Recommendation Report for Planning Permission for Works or Extension to a Dwelling

REF NO: LU/267/21/HH

LOCATION: 21 East Ham Road
Littlehampton
BN17 7AW

PROPOSAL: Erection of single storey side extension, single storey other side porch extension and alterations to fenestration following the demolition of existing side extension

REV	NOTES	DATE
 INTERIOR ARCHITECTURE + DESIGN		
PROJECT 21 EAST HAM ROAD Littlehampton, West Sussex, BN17 7AW		
DRAWING Proposed Elevations		
DRAWN BY JP	SCALE 1:50 @ A1	
DATE Aug 2021	REVISION	
DRAWING NO. 10043 - DPA - 004

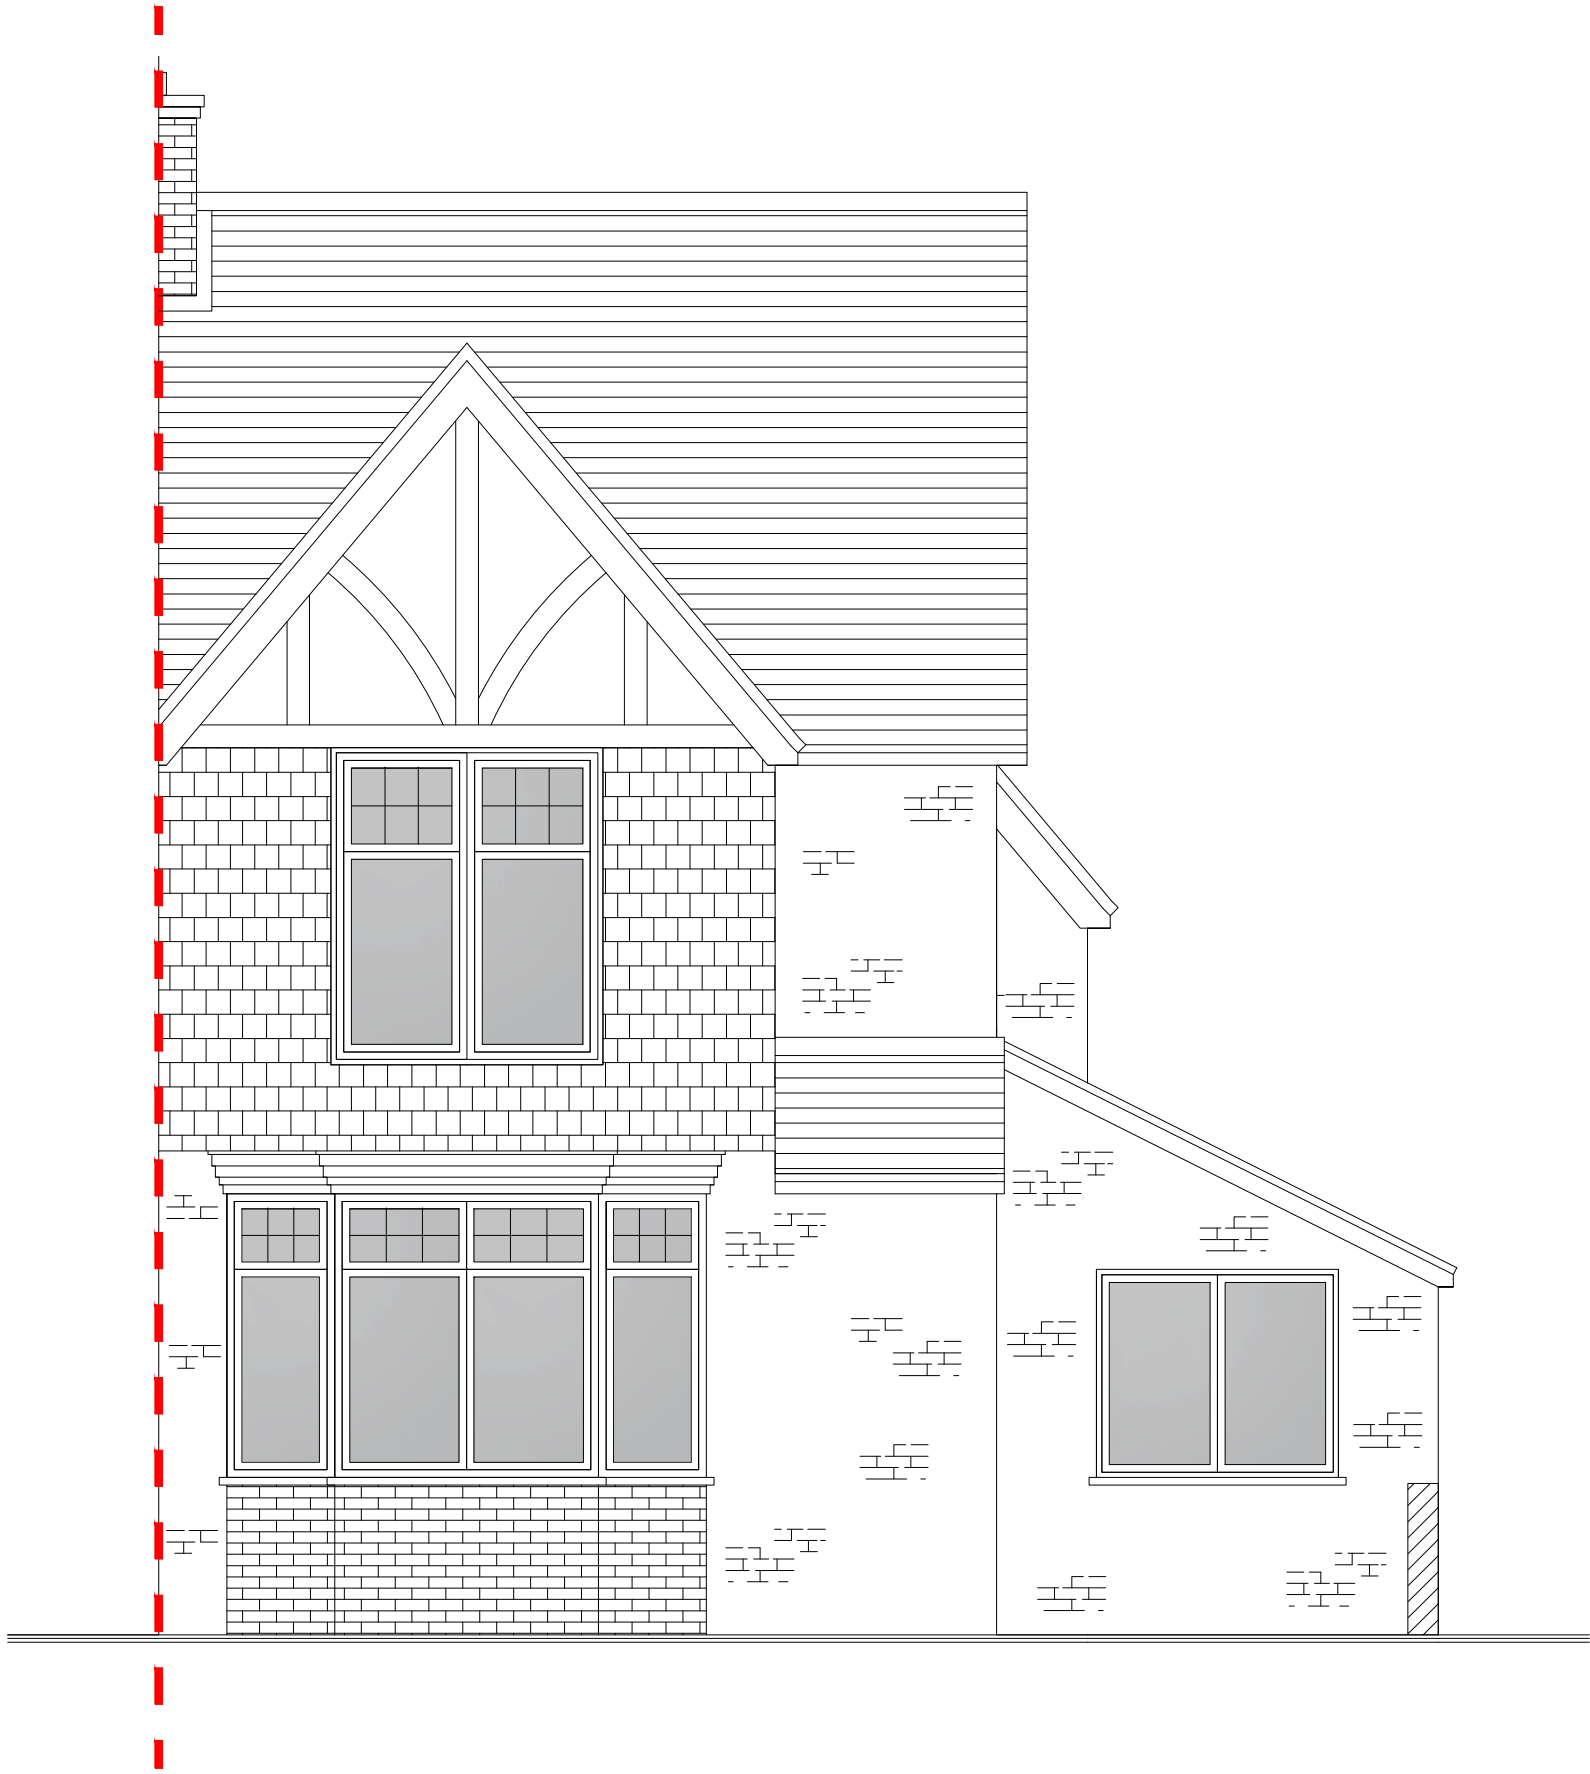
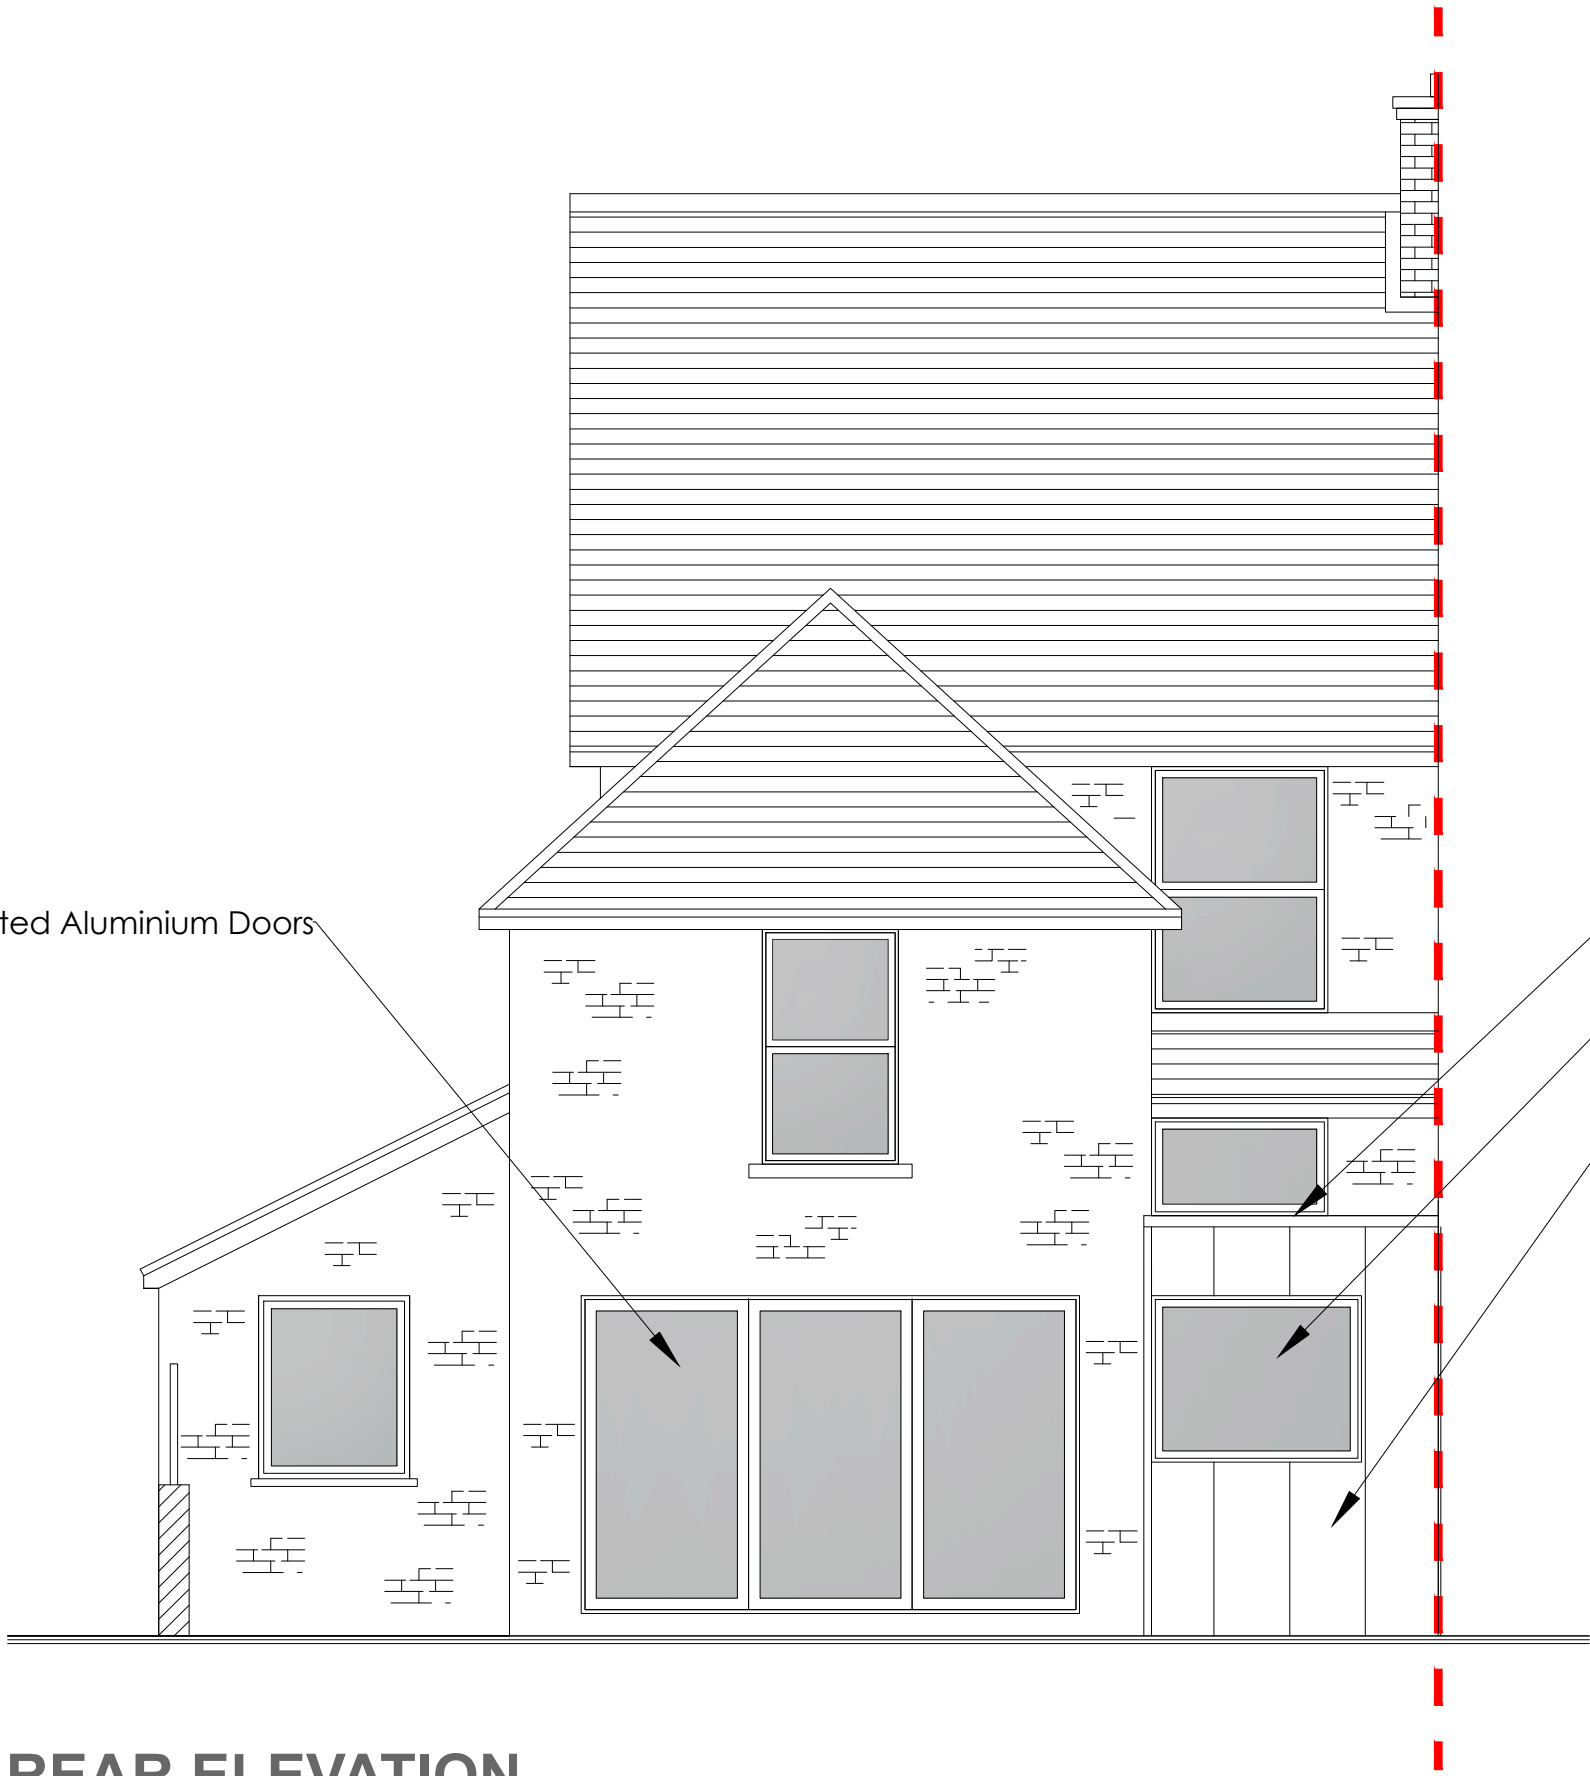
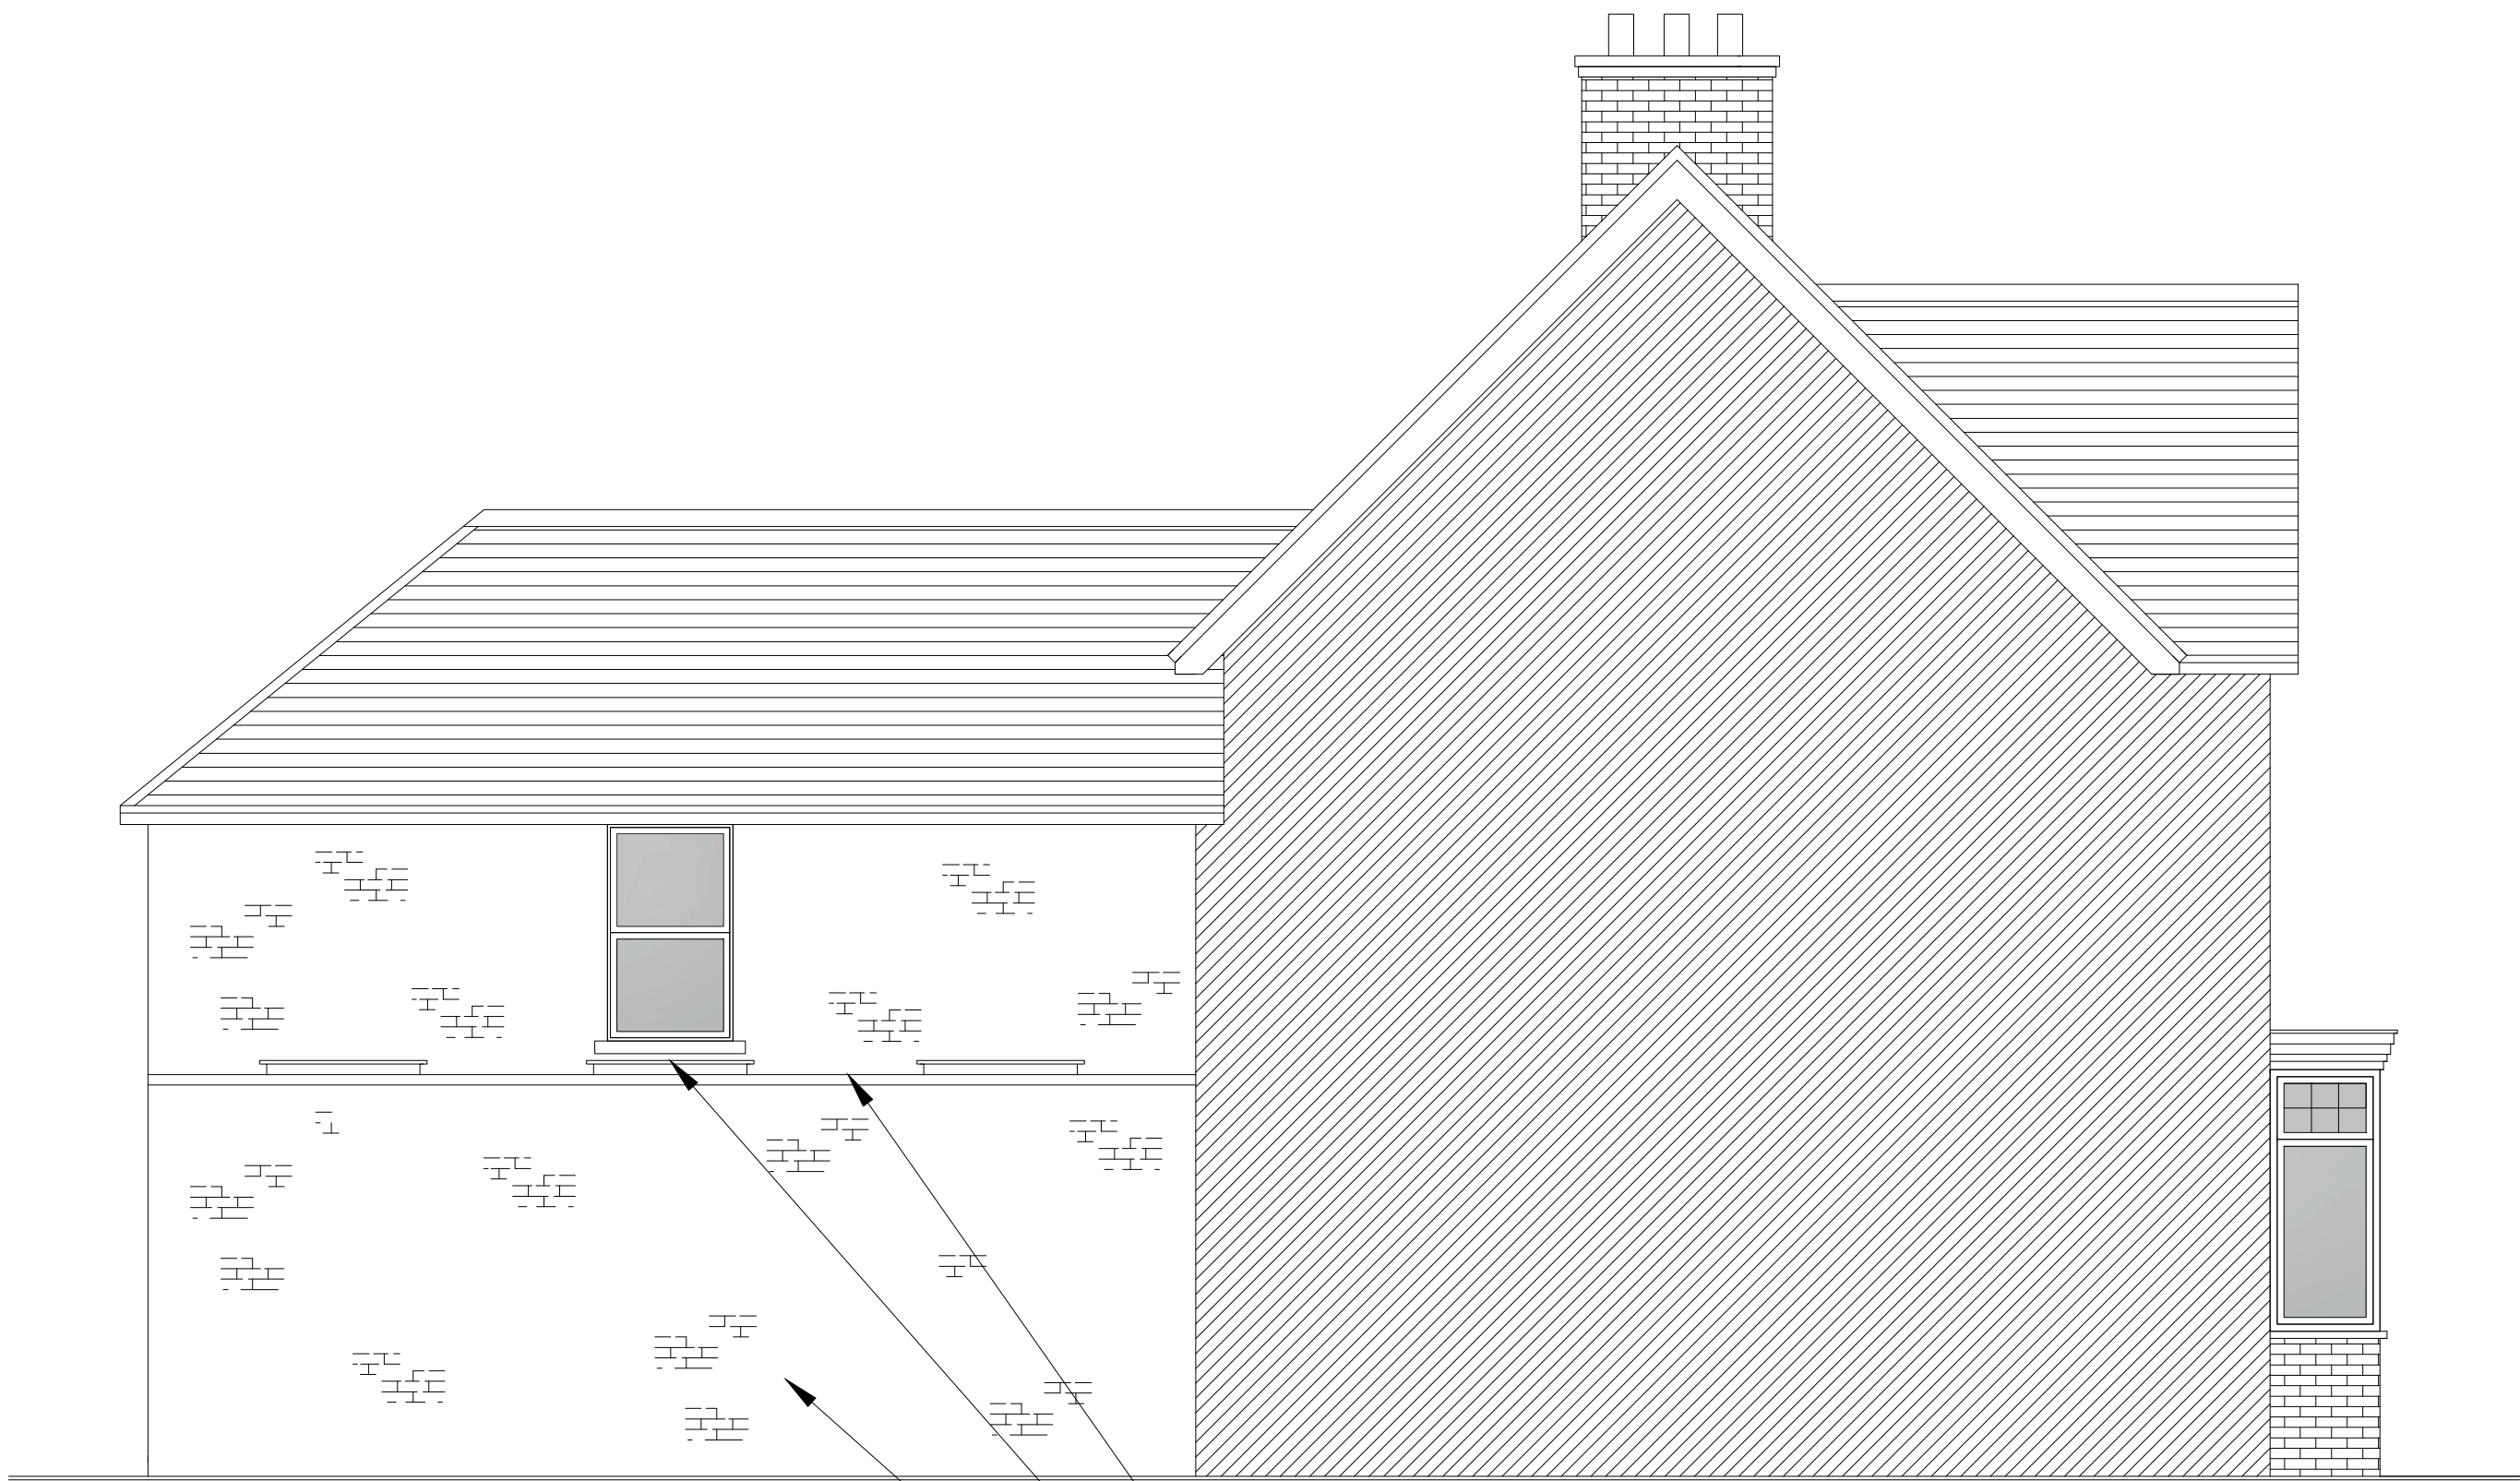
The front and side elevation will be traditionally styled with a pitched roof and utilise materials which are currently found on the existing dwelling and within the local area. The rear addition takes on a much more modern approach and includes a flat roof and zinc exterior cladding, this is considered acceptable as it is to the rear of the property and not visible from the public realm, design guidance also allows for greater design freedom for rear extensions.

The side/front extension will be visible from East Ham Road and Gloucester Place. The extension will be located behind the primary elevation but it will sit forwards of the elevation fronting Gloucester Place. Due to its vernacular styling, scale and siting these extensions are appropriate to both the host dwelling and street scenes.

The rear extension will be flat roofed and to an overall height of 2.9m and be located on the shared boundary with no. 19 East Ham Road. The proposal does not accord with the 45-degree rule for rear

extensions, however this is not seen as a reason to refuse the application as neither does the existing structure. It is therefore considered not to be overbearing on no. 19 East Ham Road.

The fenestration proposed to the rear extension will be to ground floor level and face the private rear garden of the property and as such no negative overlooking is considered to occur.
